NORFOLK BOREAS OFFSHORE WIND FARM

Planning Inspectorate Reference: EN010087

Natural England's response to
DCO documents submitted at Deadline 5 and 6

31st March 2020

Co-ordinate system: British National Grid EPSG: 27700

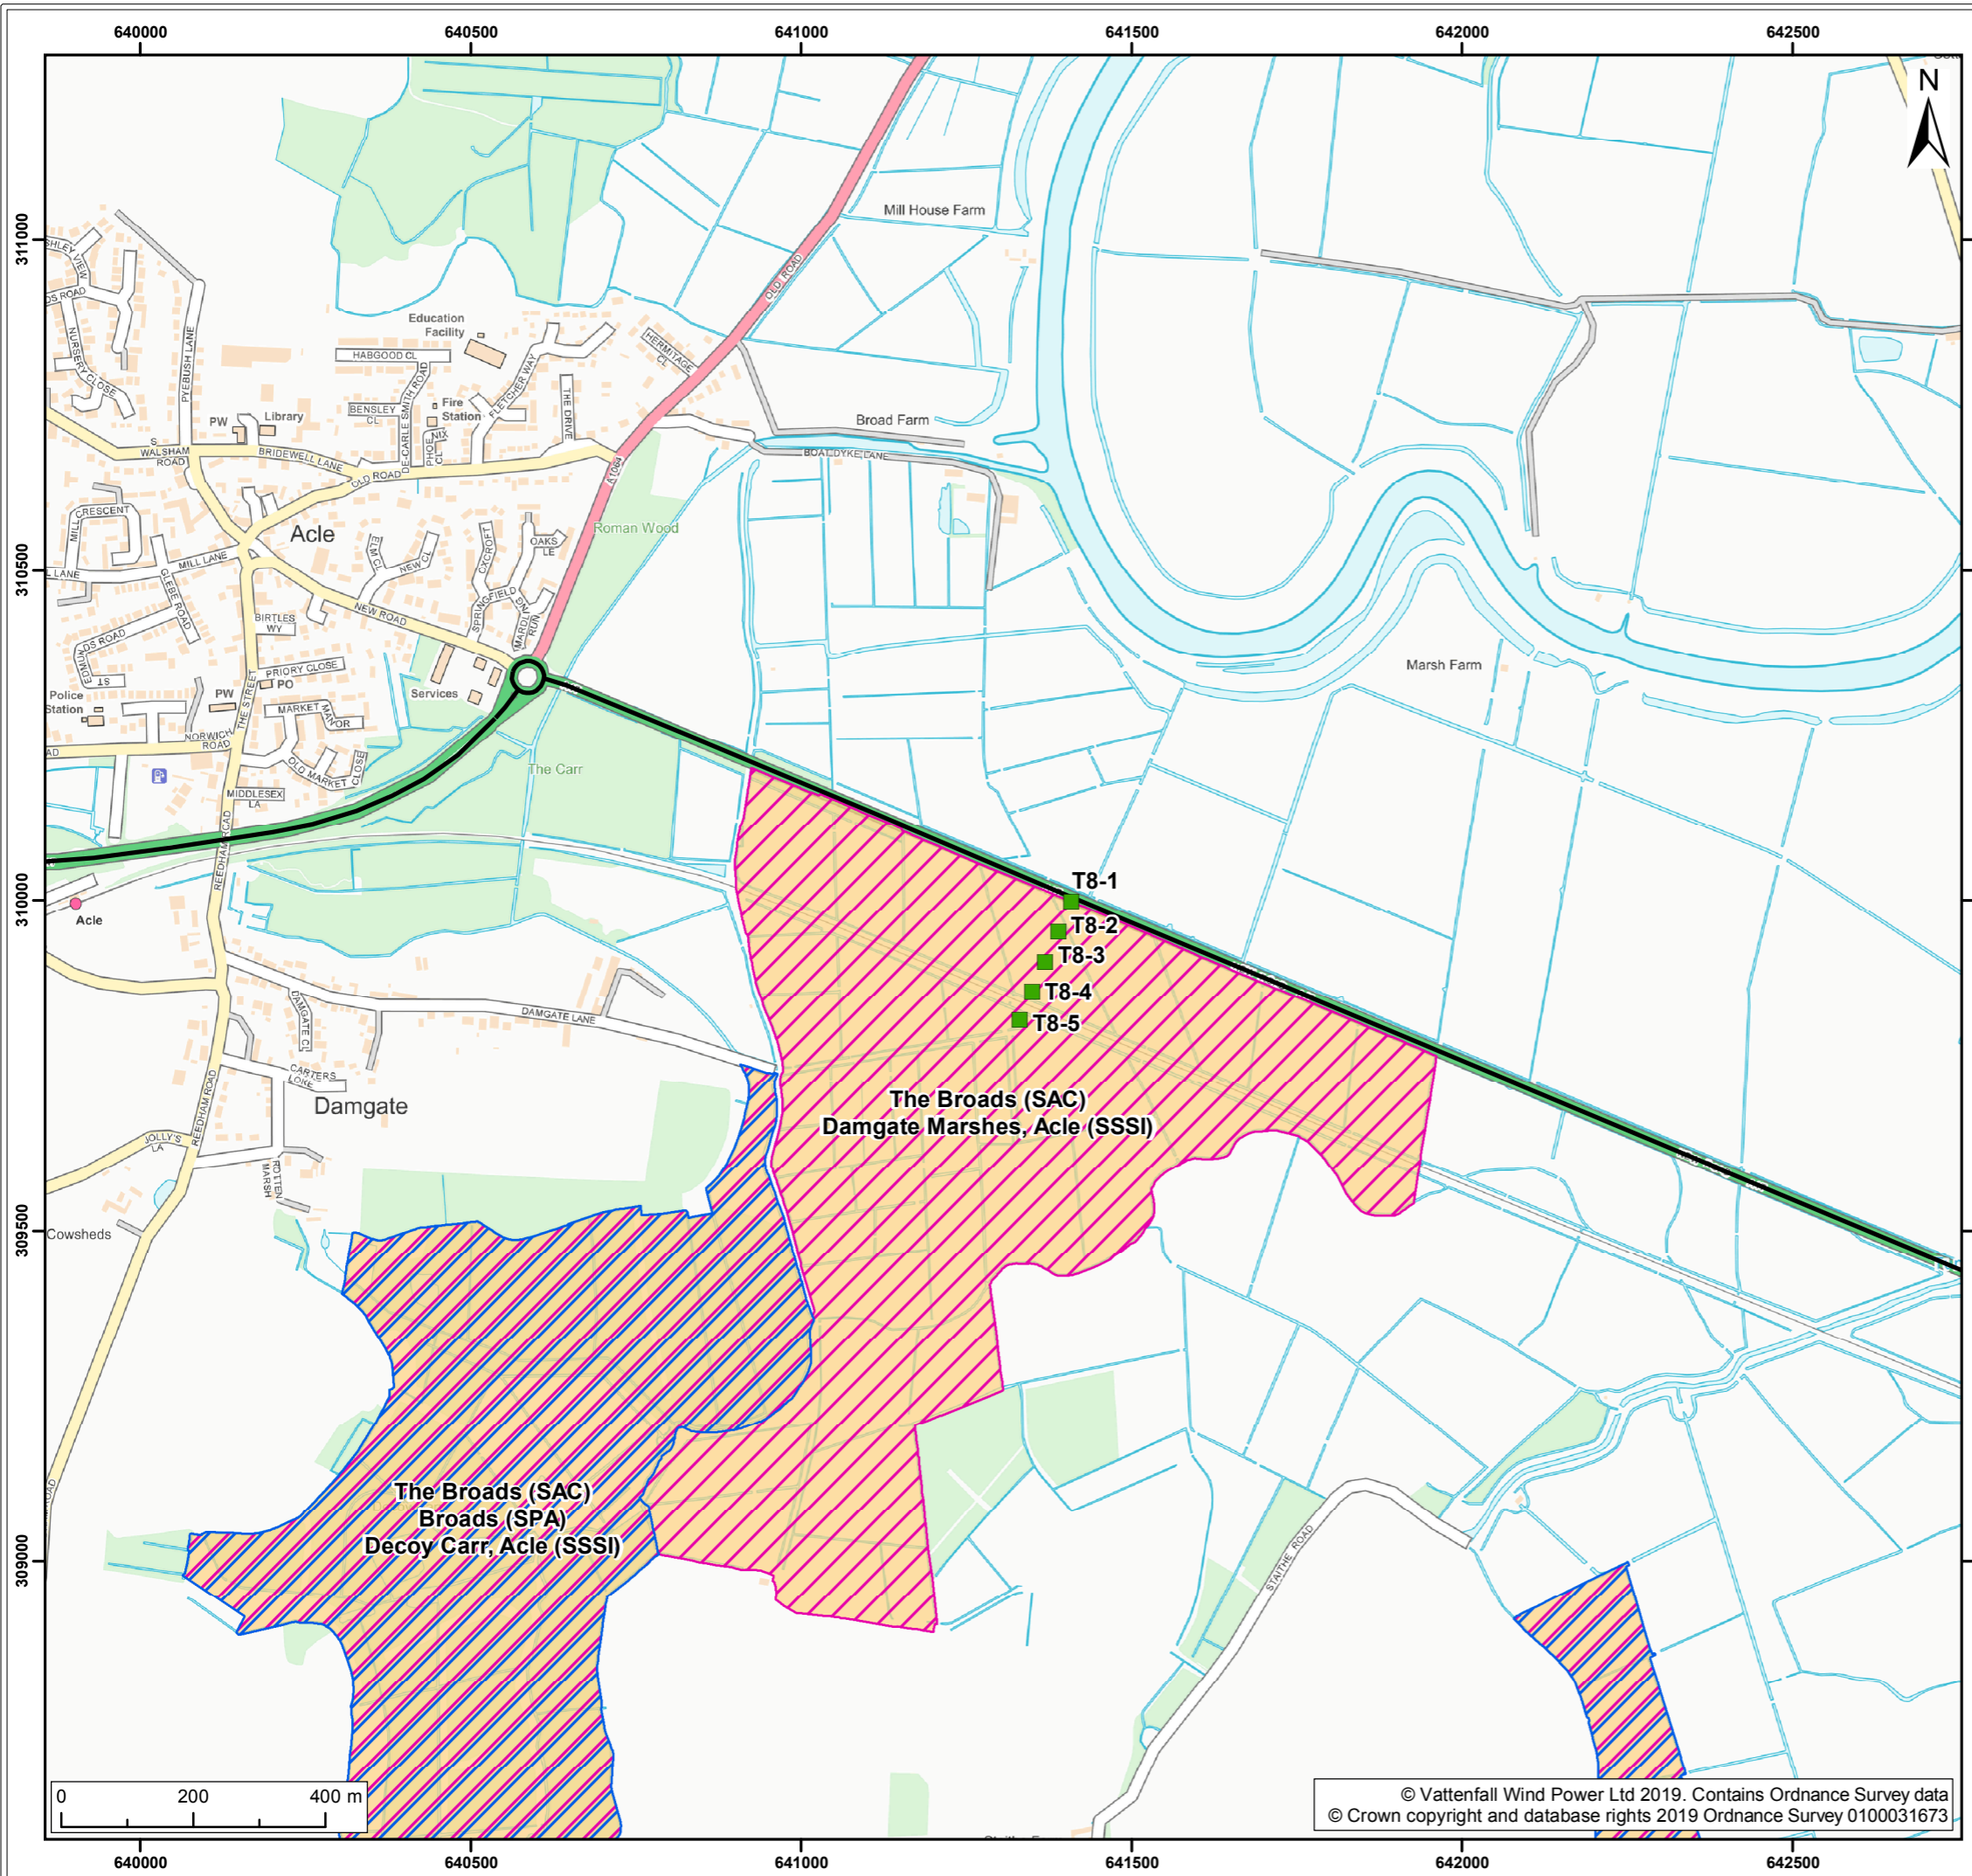
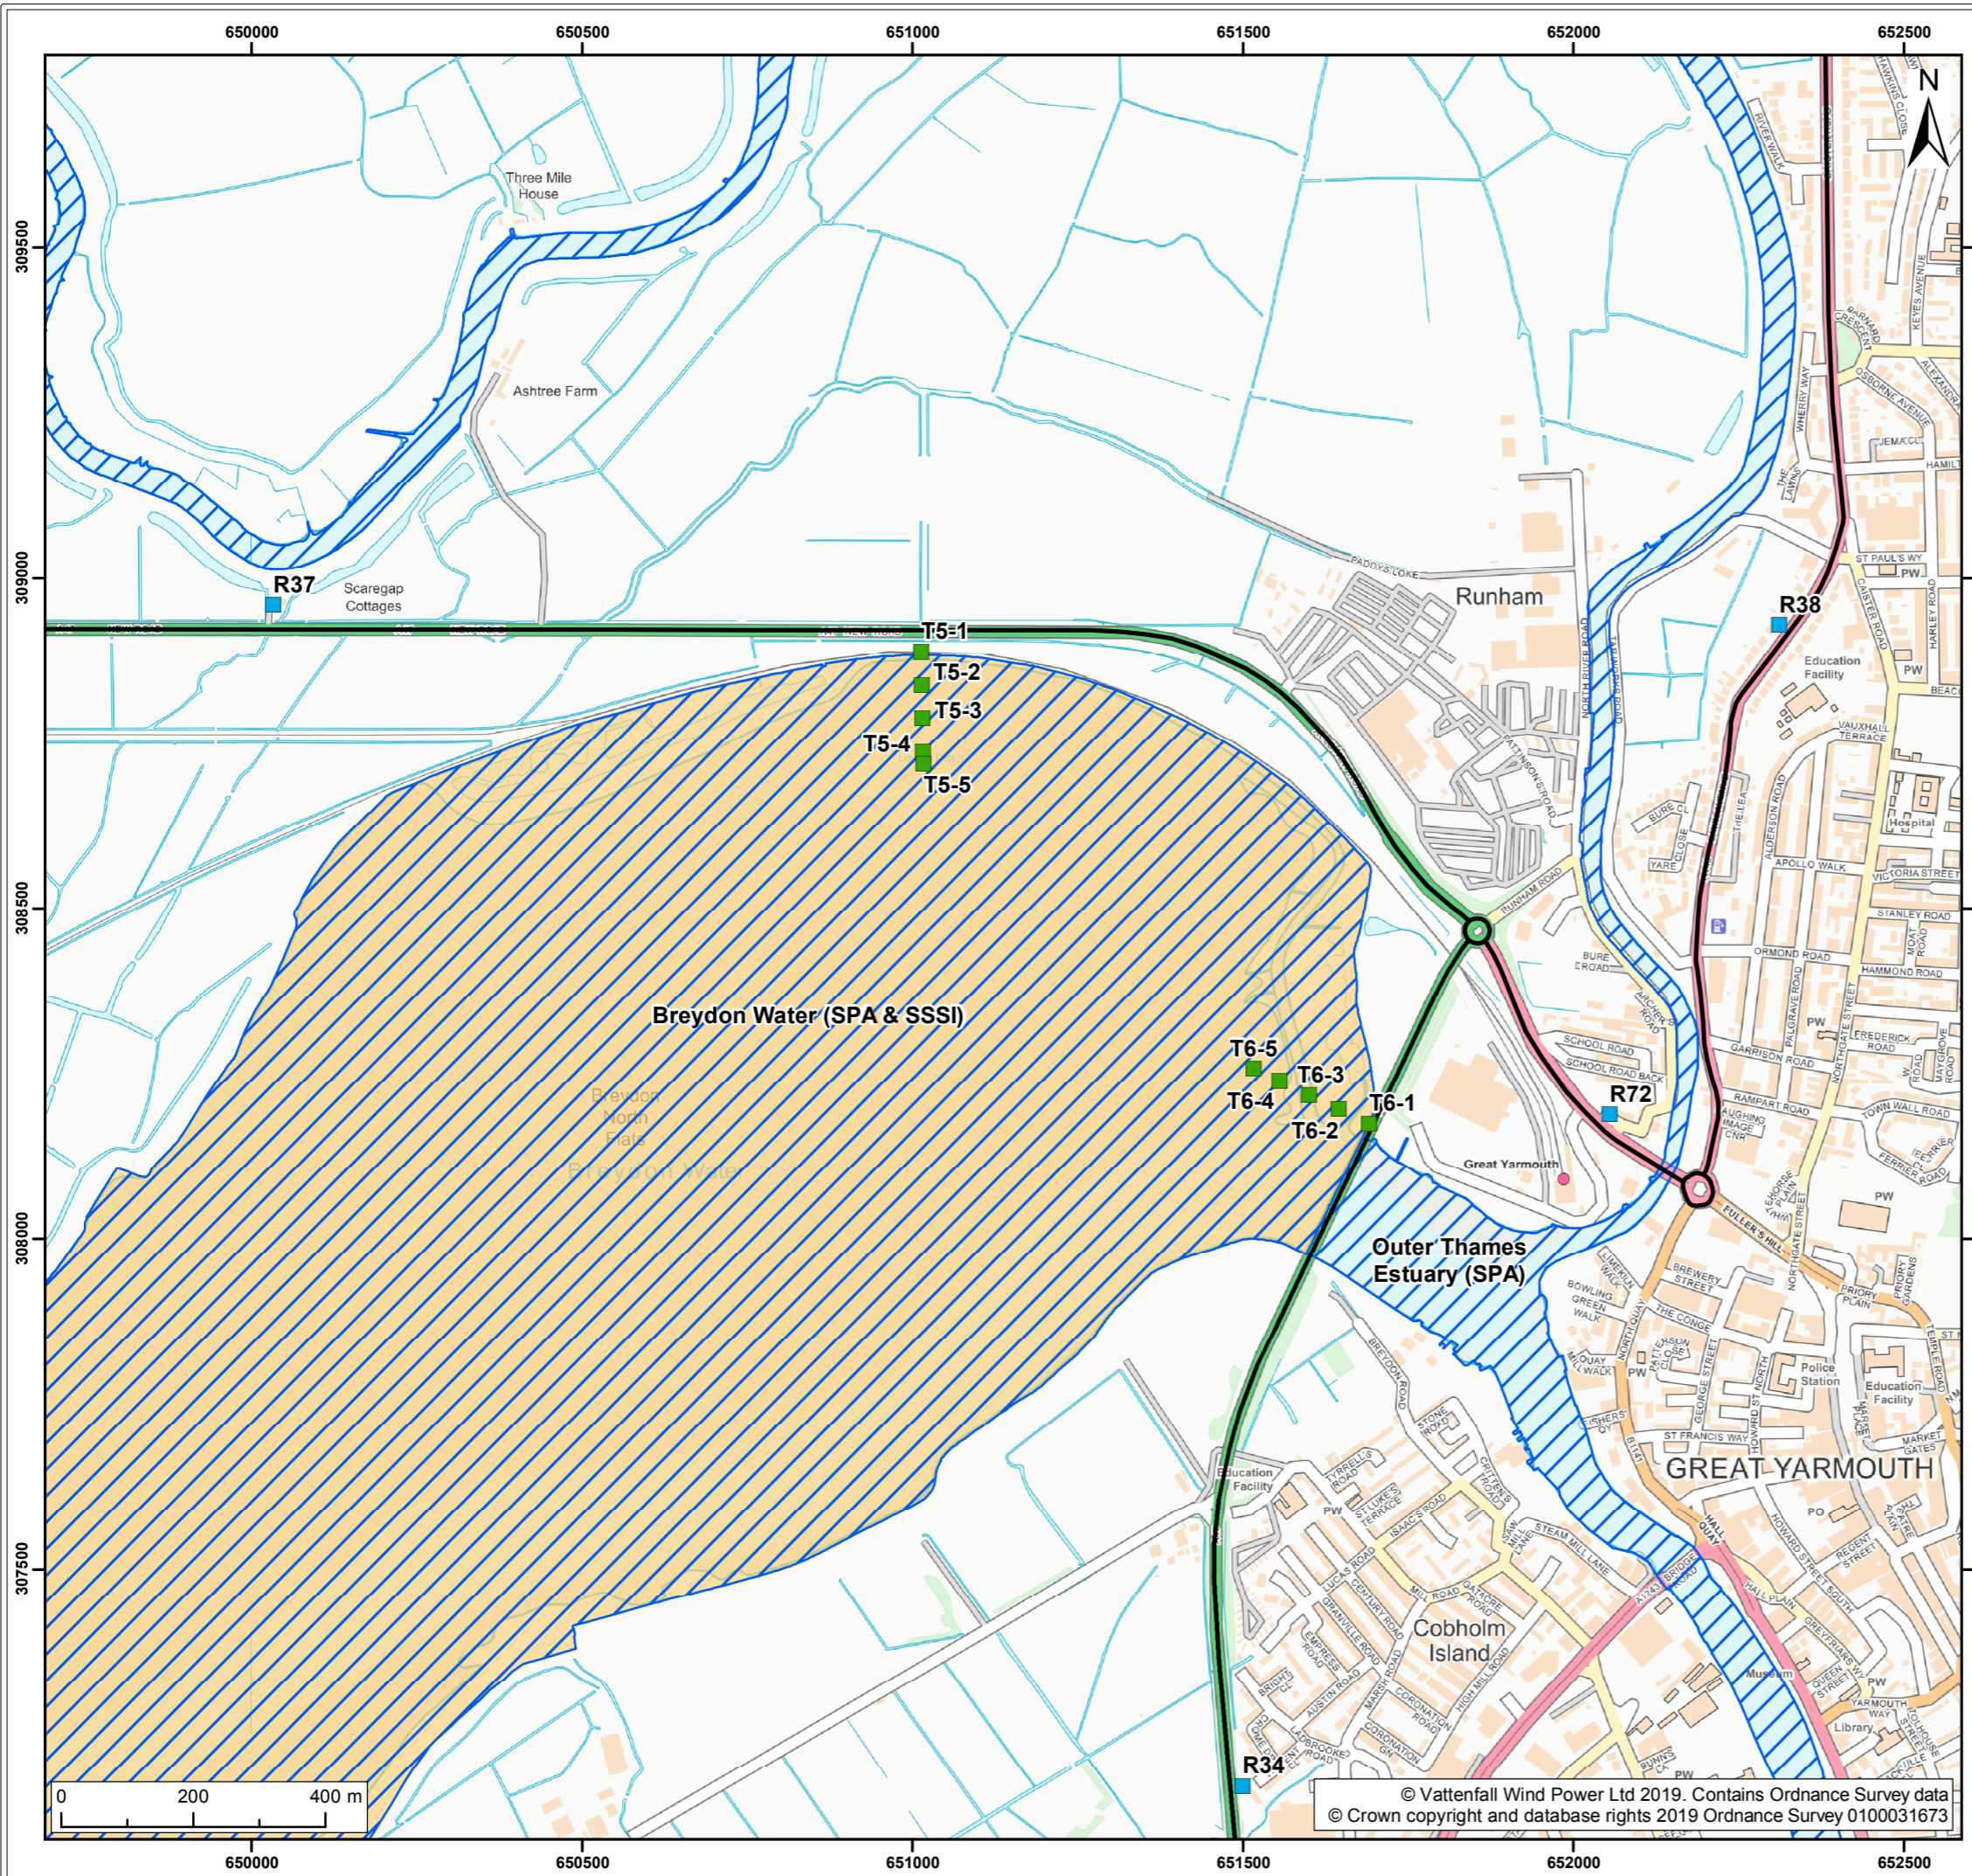
8.8 Outline Traffic Management Plan Version 3		
74	17	Welcome inclusion of para 74 in OTMP, advise that the Applicant include ES figure 26.5 as an Appendix to the OTMP to allow reference should the ES not be publicly available by the time of construction.
		This does not show the location of designated sites sensitive to air quality in relation to the traffic and HGV routes, either alone or in combination with other developments. Advise that the Applicant include ES figure 26.5 as an Appendix to the OTMP.
